Barnsley Metropolitan Borough Council
Development Control

Our ref: RA/2025/149119/01-L01
Your ref: 2025/1077

Change of use from dwellinghouse (class c3) to 4-bed 4-person HMO (class c4) (amended description).

329 Midland Road, Royston, Barnsley, S71 4AZ

Revision	Date	Initials
Client		
Project	PROPOSED CHANGE OF USE 329 MIDLAND ROAD, ROYSTON, BARNSELY, S71 4AZ	Project No. 2693
Drawing	SCHEME PROPOSAL EXISTING AND PROPOSED FLOOR LAYOUTS	Drawing No. P.100
Drawn	Scale @ A1 1:50	Revision -
Check	Date 02.12.2025	
SW

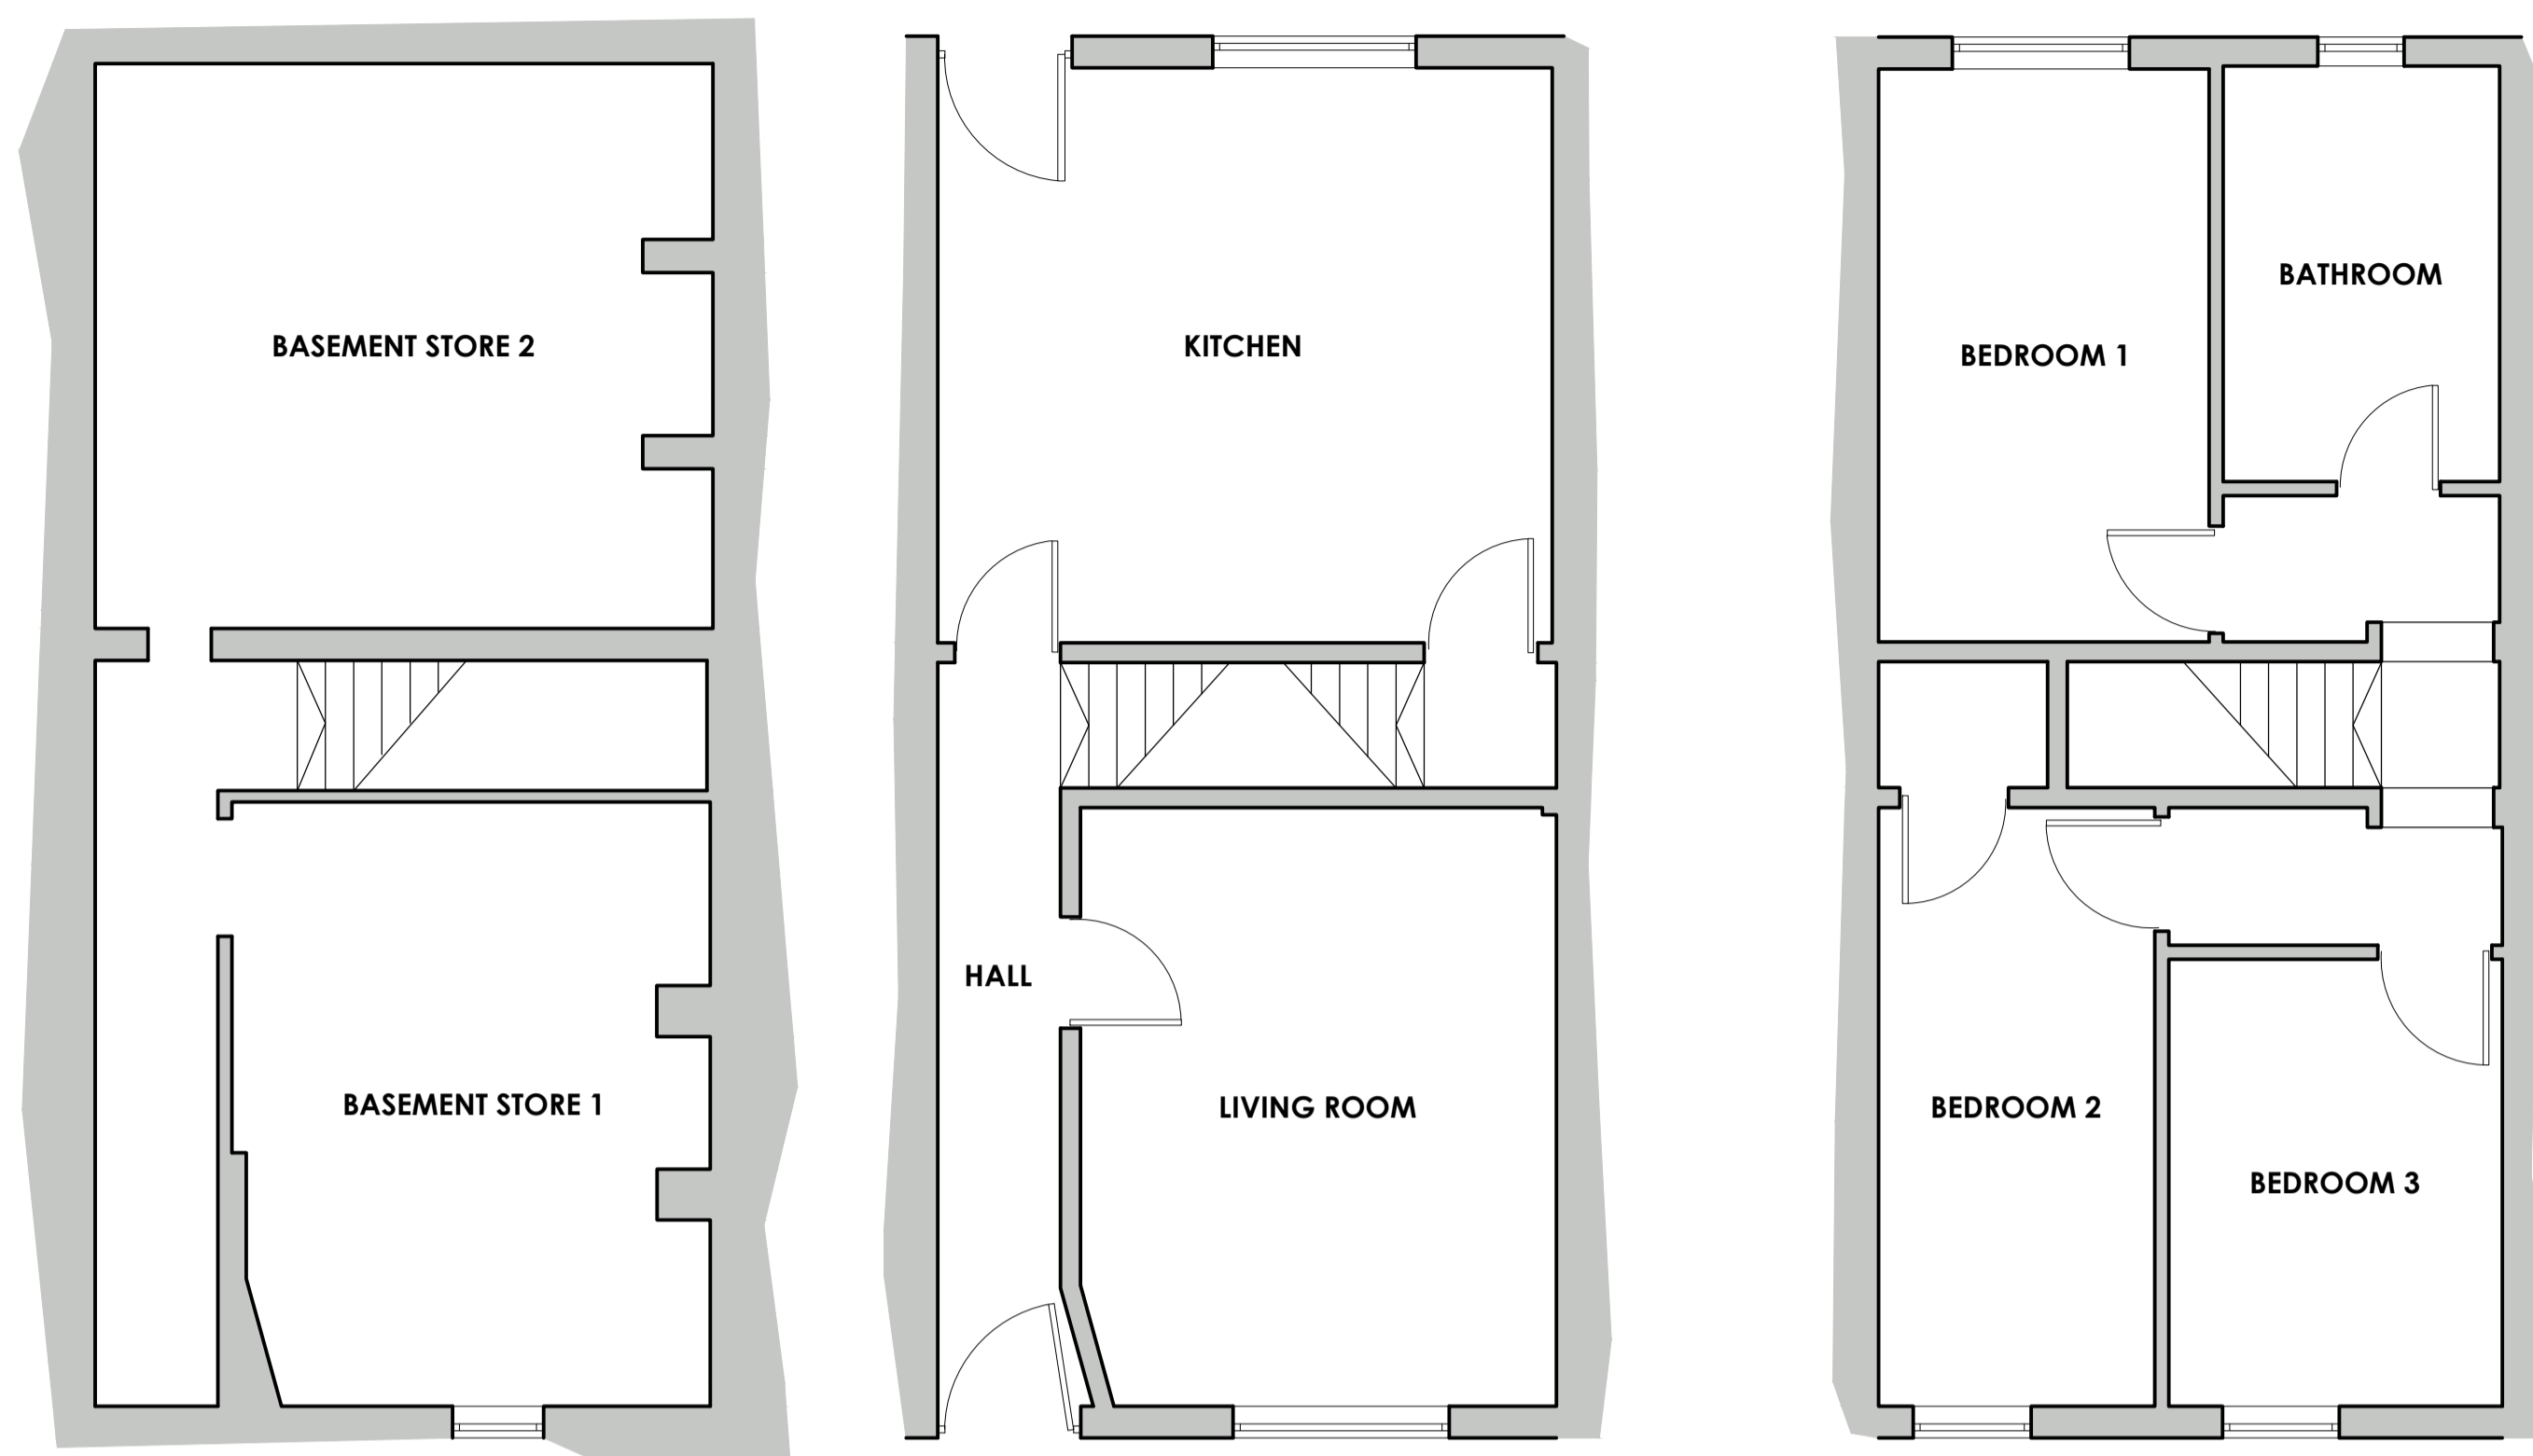
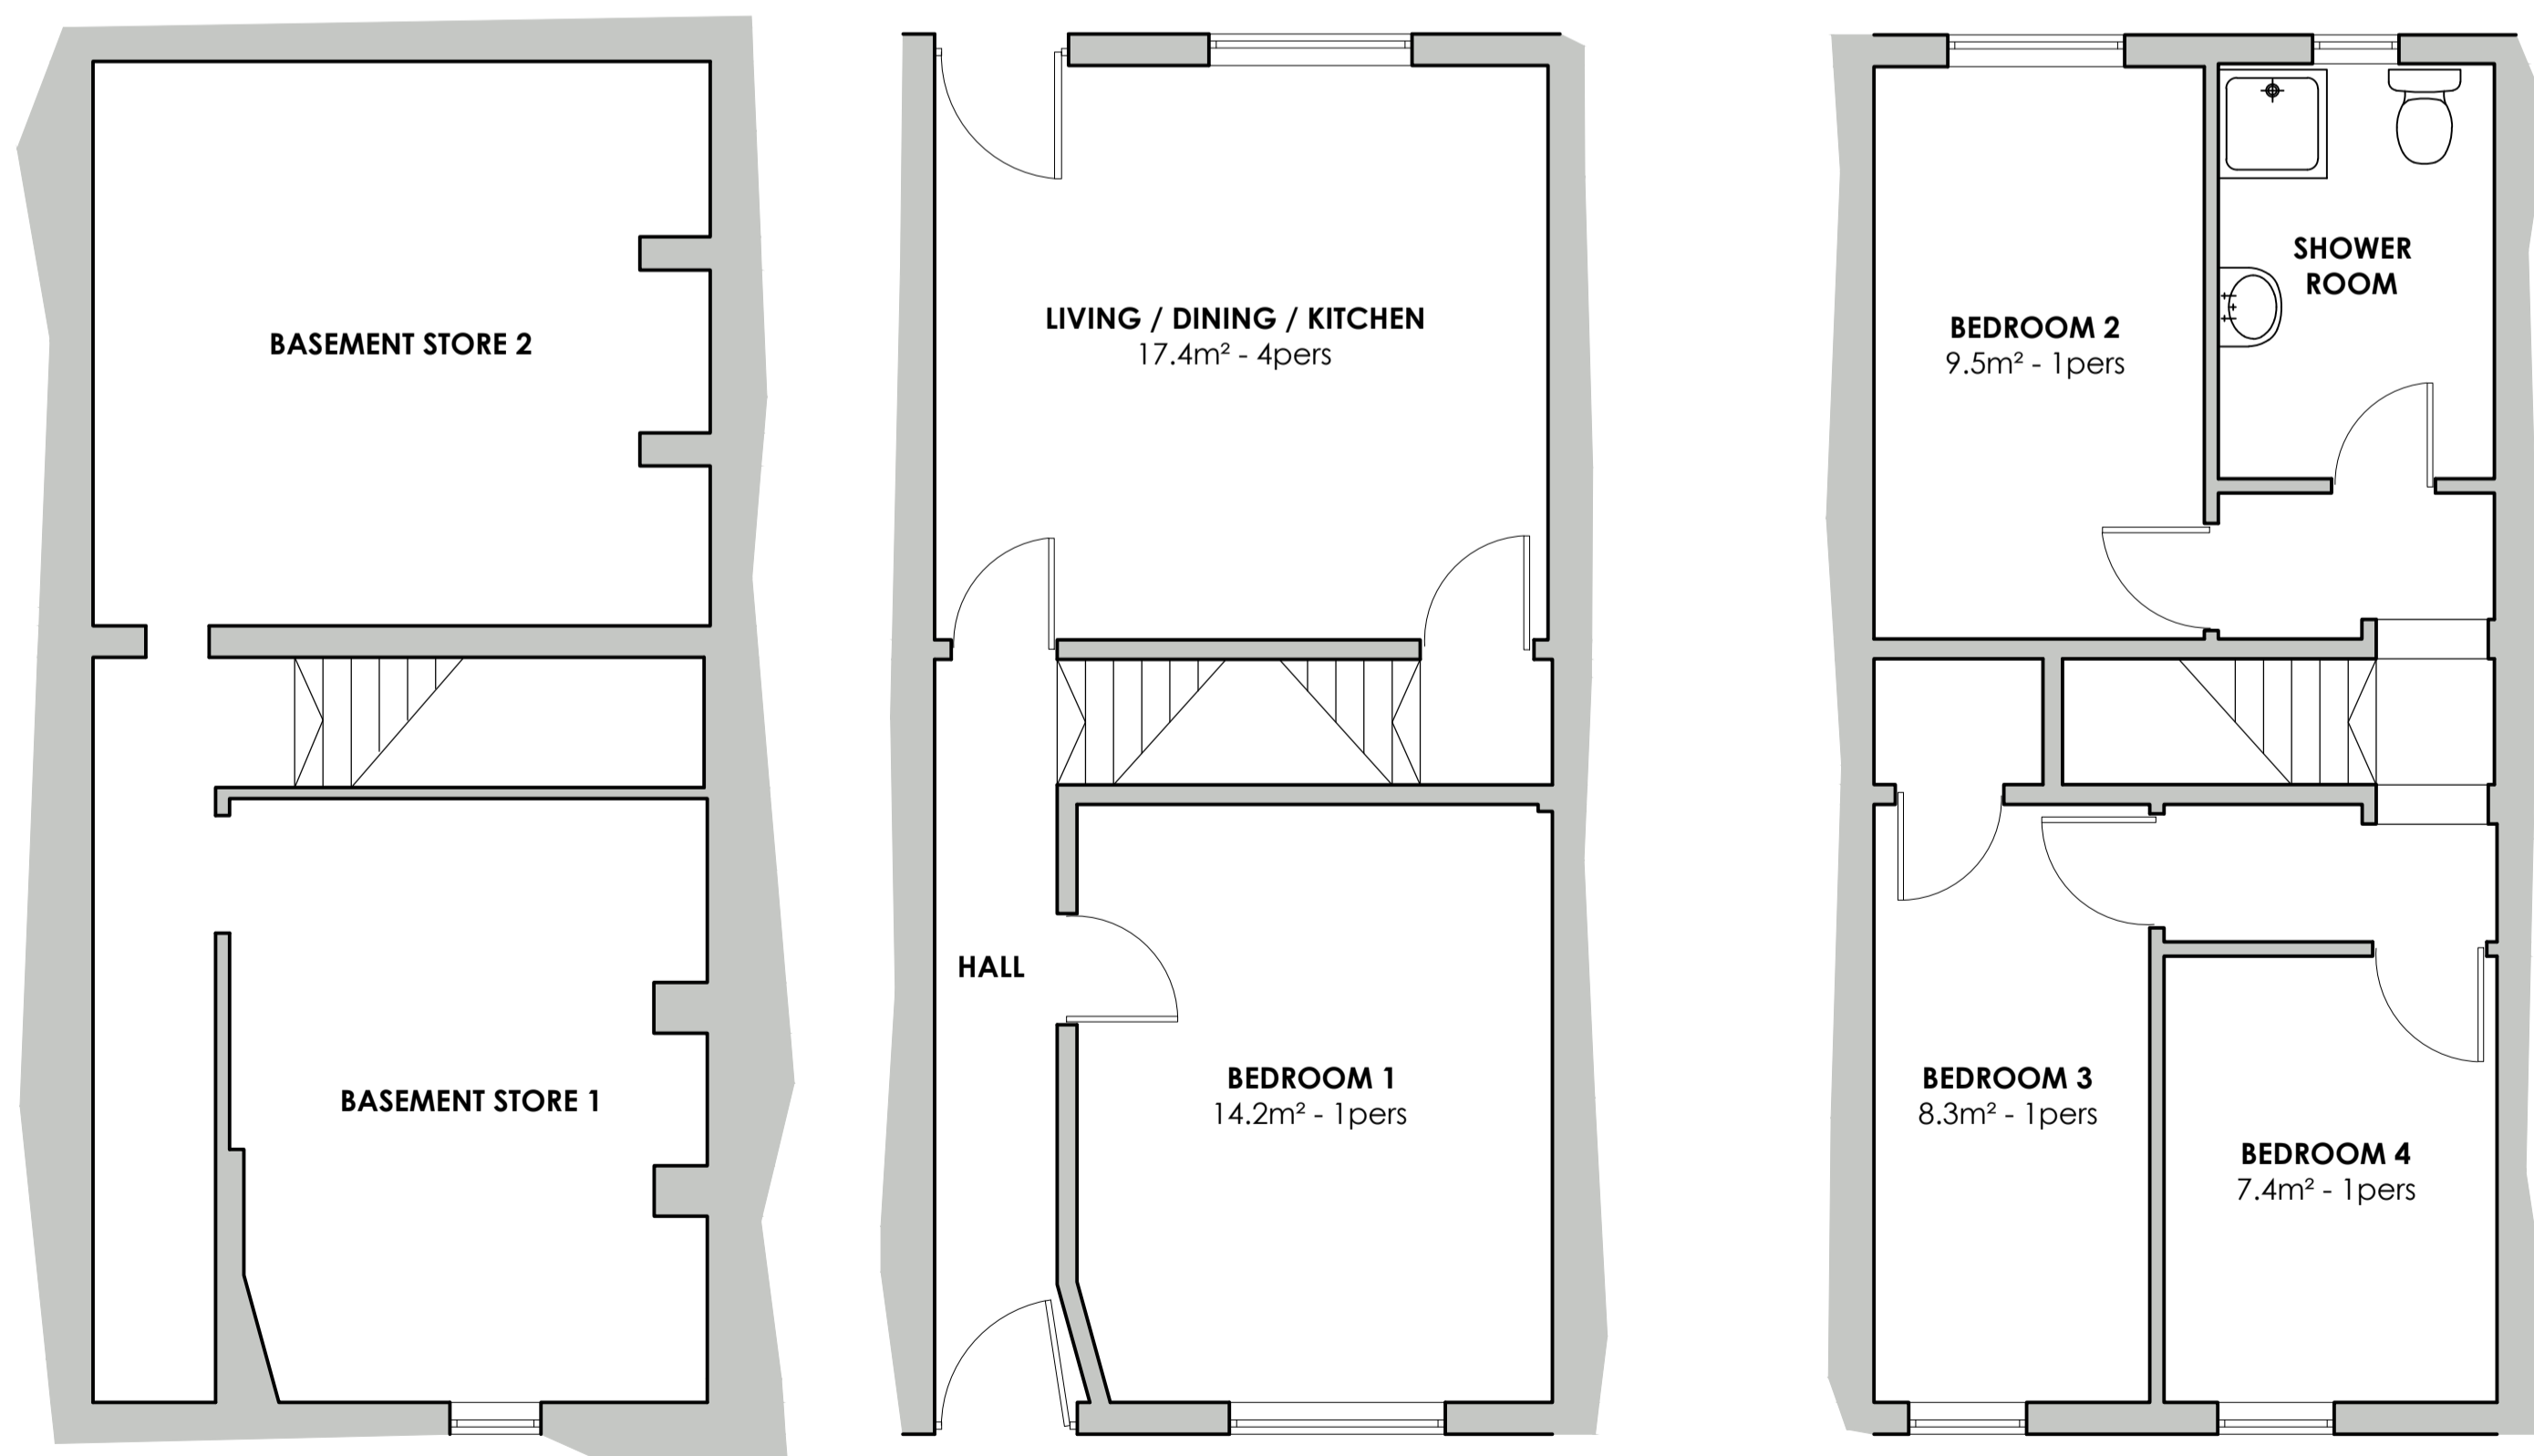
We note the proposal is for a change of use that introduces ground floor sleeping. We note there is no change to the existing footprint of the building. However the site is within Flood Zone 3 and is classed as More Vulnerable.

We note on the application form, the question “Is your proposal within 20 metres of a watercourse (e.g. river, stream or beck)?” the applicant has answered “no”. A culverted ordinary watercourse runs beneath property.

In the absence of a flood risk assessment (FRA), we **object** to this application and recommend that planning permission is refused.

The application site lies within Flood Zone 3, which is land defined by the planning practice guidance as having a high probability of flooding. The NPPF (paragraph 181, footnote 63) and the Flood Risk and Coastal Change Planning Practice Guidance (paragraphs 20 and 21) states that an FRA must be submitted when development is proposed in such locations.

An FRA is vital to making informed planning decisions. In its absence, the flood risks posed by the development are unknown. This is sufficient reason for refusing planning permission.

To overcome our objection, the applicant should submit an FRA which demonstrates that the development is safe without increasing risk elsewhere. Where possible, it should reduce flood risk overall.
